Subject: 112 Lambert Lane
Fuquay Varina, NC 27526
Framing Modification Letter
Harnett County Permit #: SFD2401-0070

Based on the request of the Contractor, 3 headers on the 1st level of the new home were modified. My assessment and recommendations are as follows:

FIRST FLOOR STRUCTURAL PLAN  
SCALE: 1/4"=1'-0"

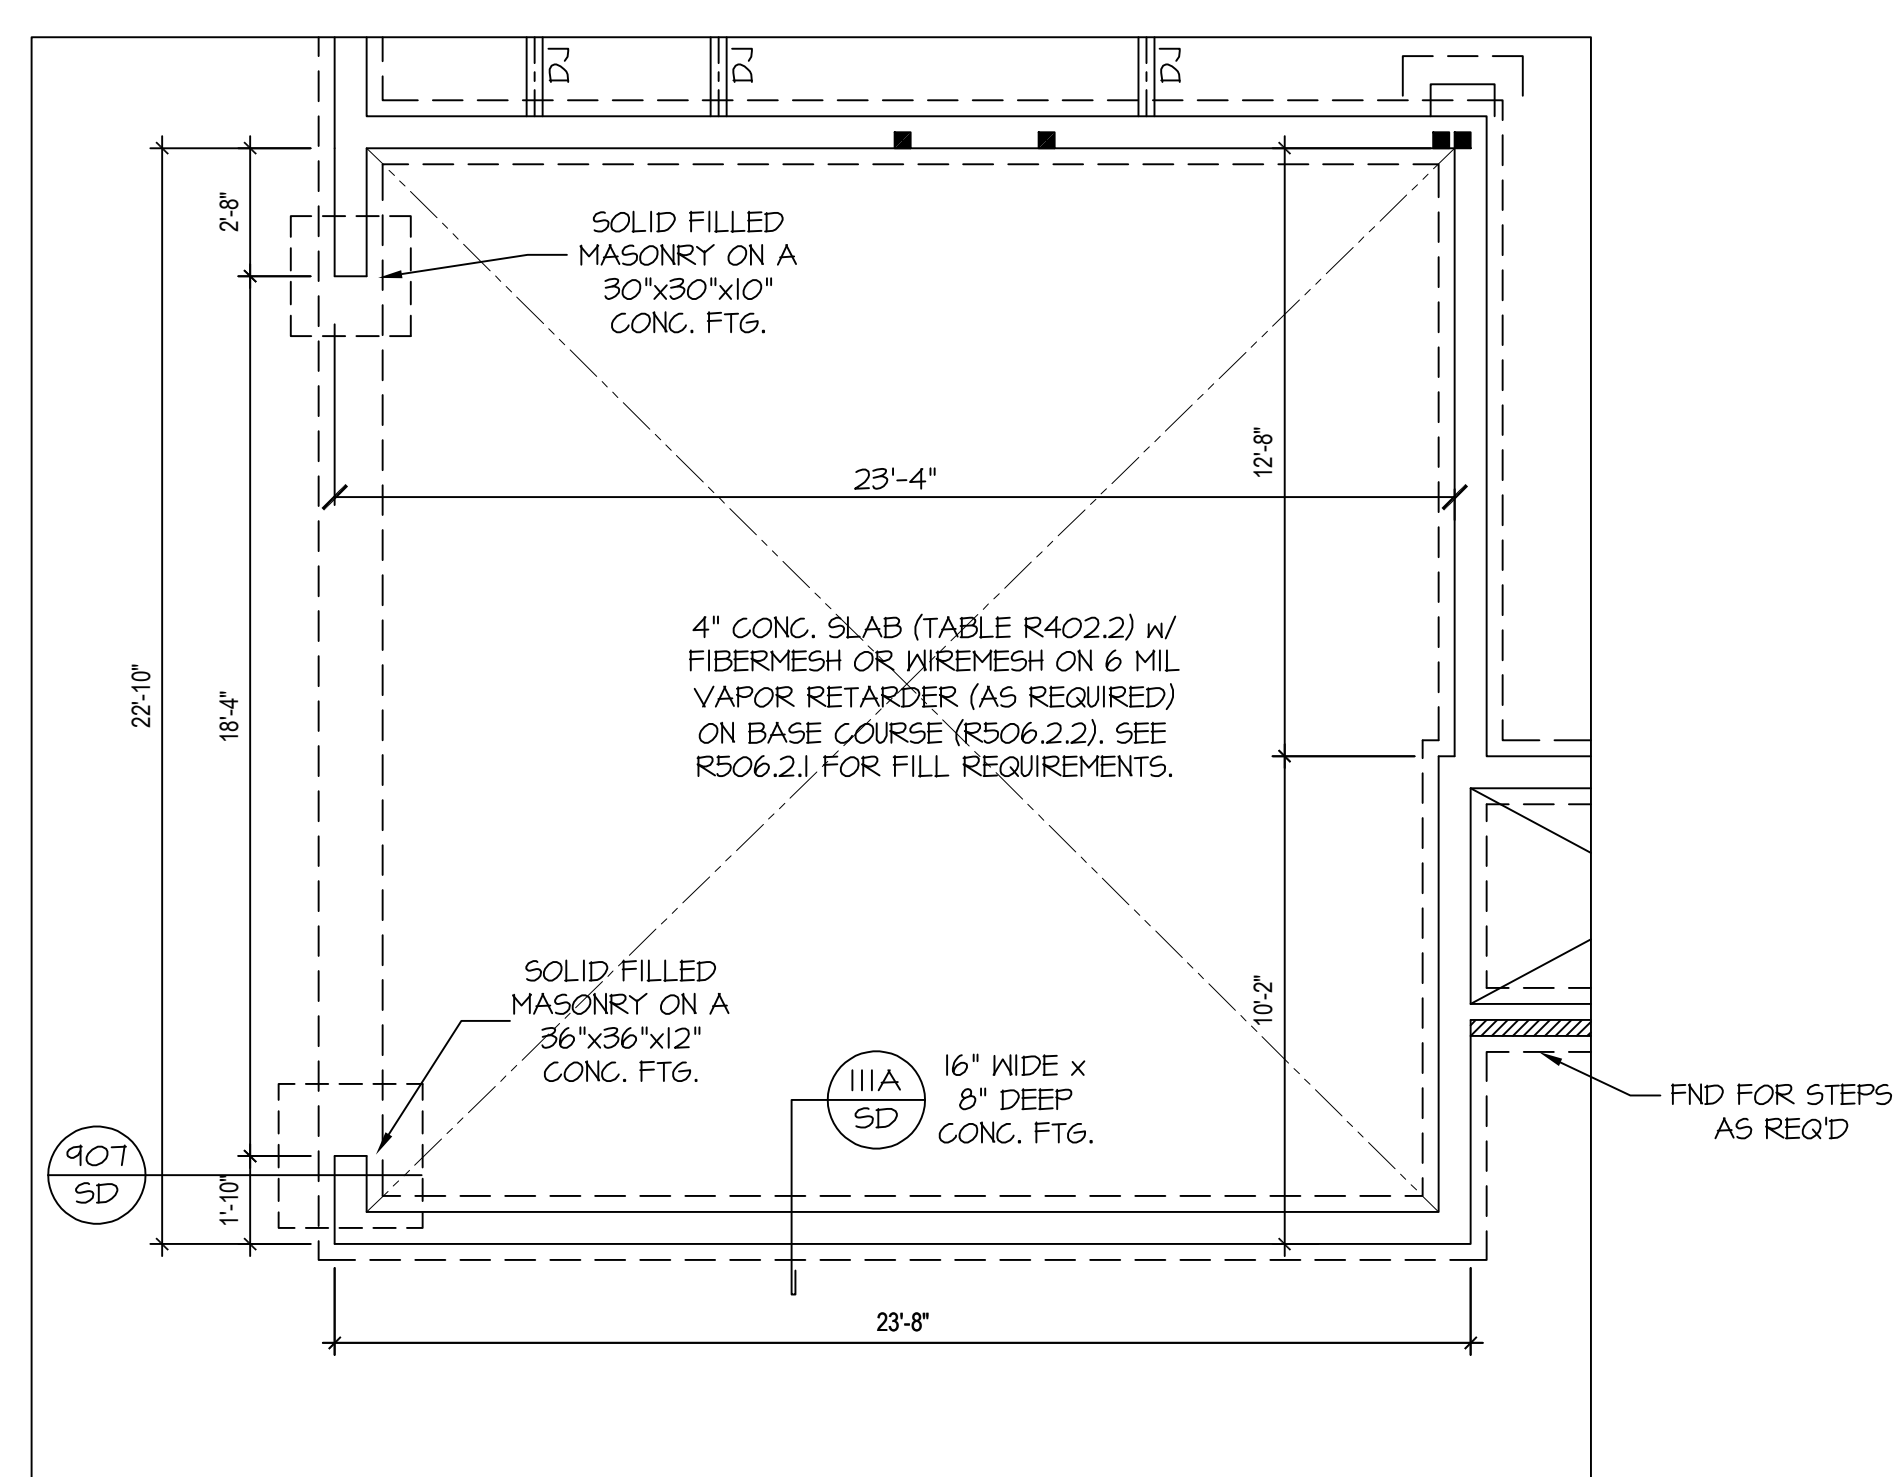
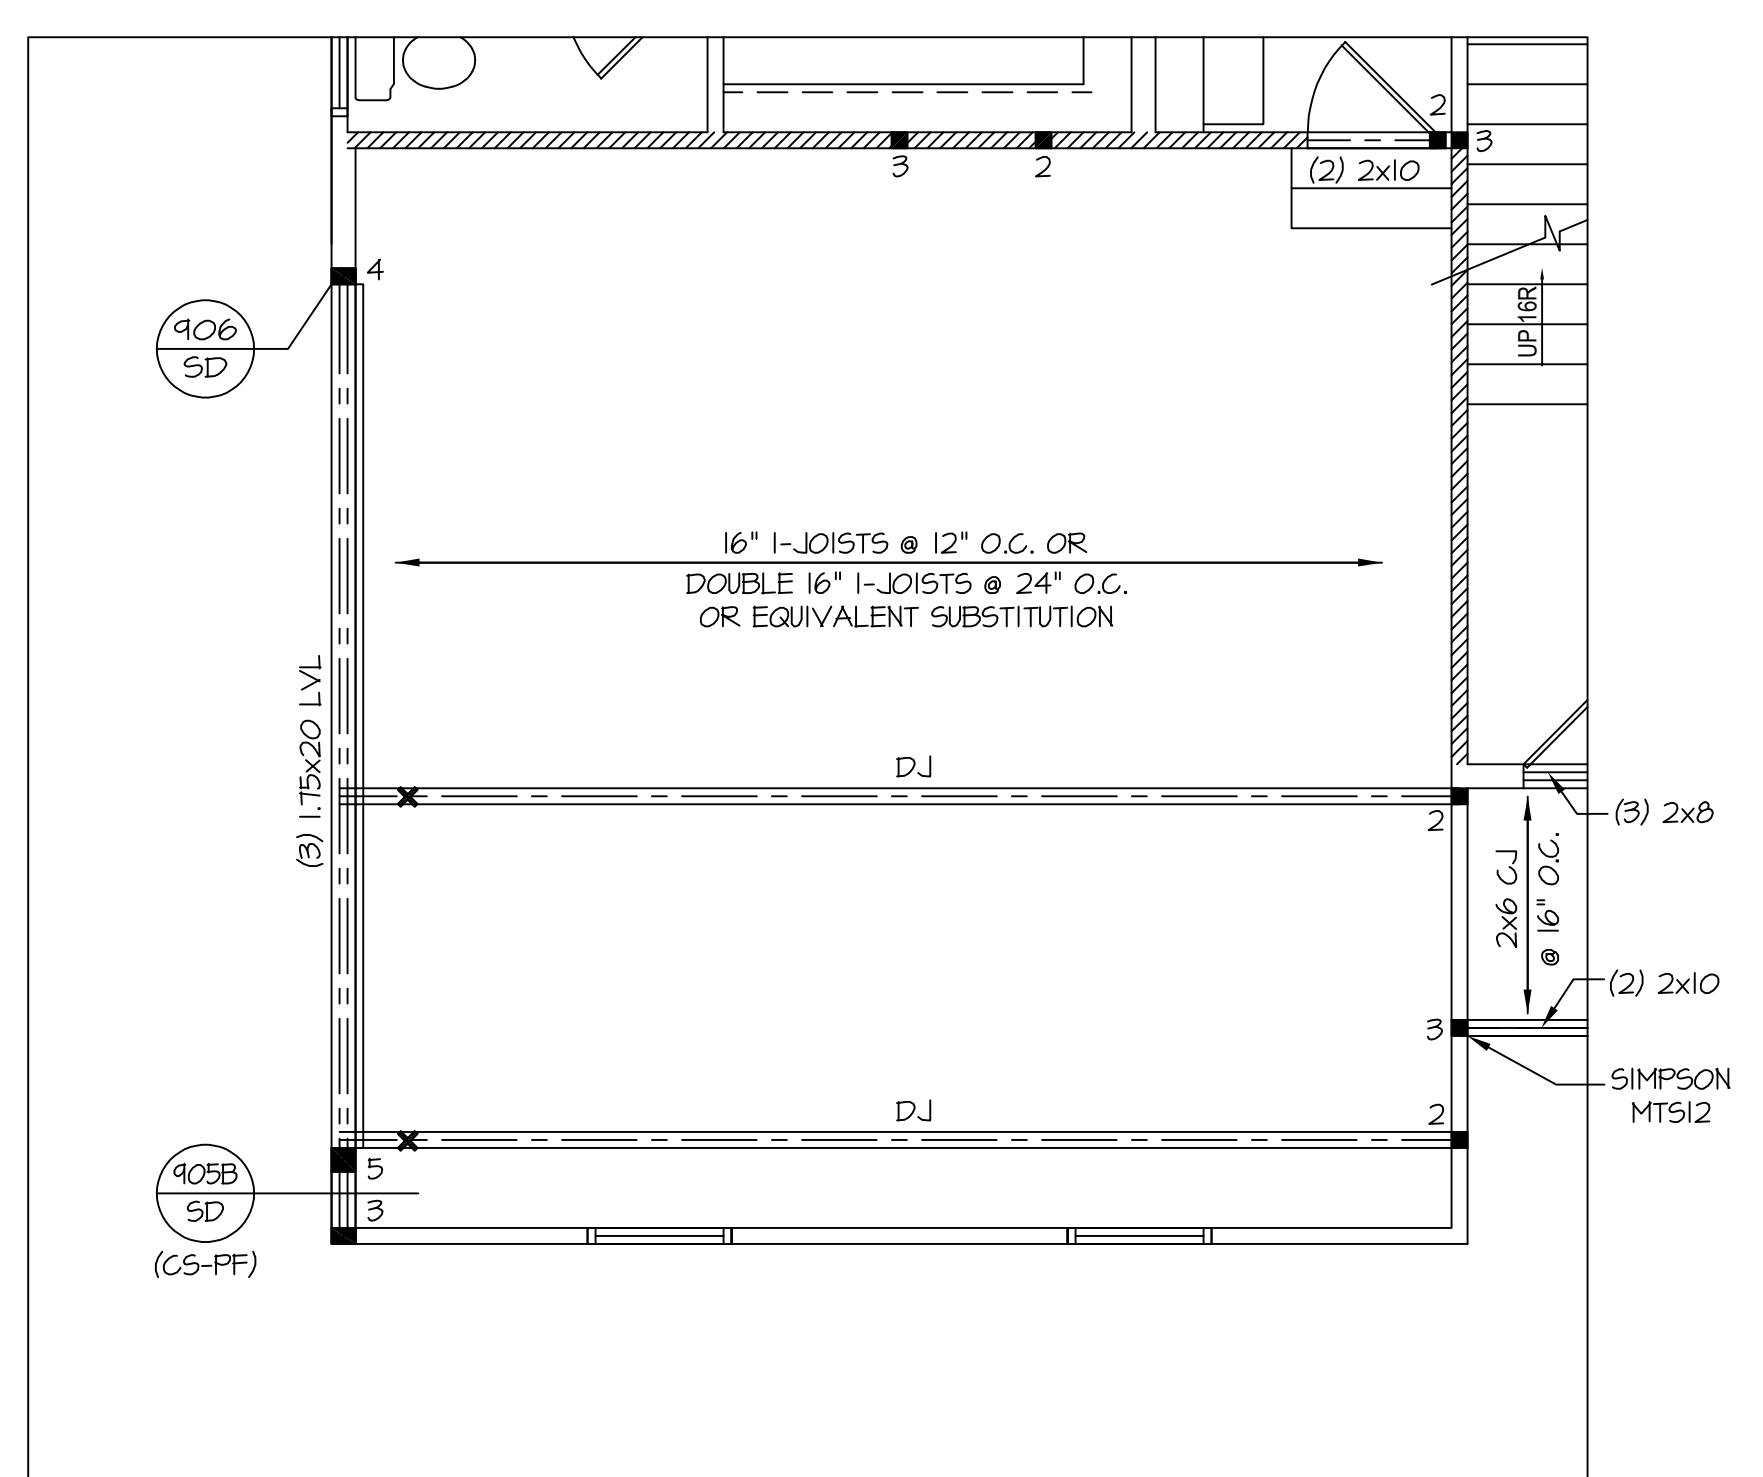
- The 3 headers were shown as double 2x10 headers on the plans (2'-8" entry door into the house from the Garage, 4' cased opening into the Family Room to the right of the stairs, and 2'-8" cased opening from the Kitchen into the Dining Room. The Contractor cut the headers down to a double 1 ½" x 8 ¼" headers with a single jack stud under each end. The modified header sizes are acceptable.

The modified headers meet all the requirements of the 2018 North Carolina Building Code for Residences.
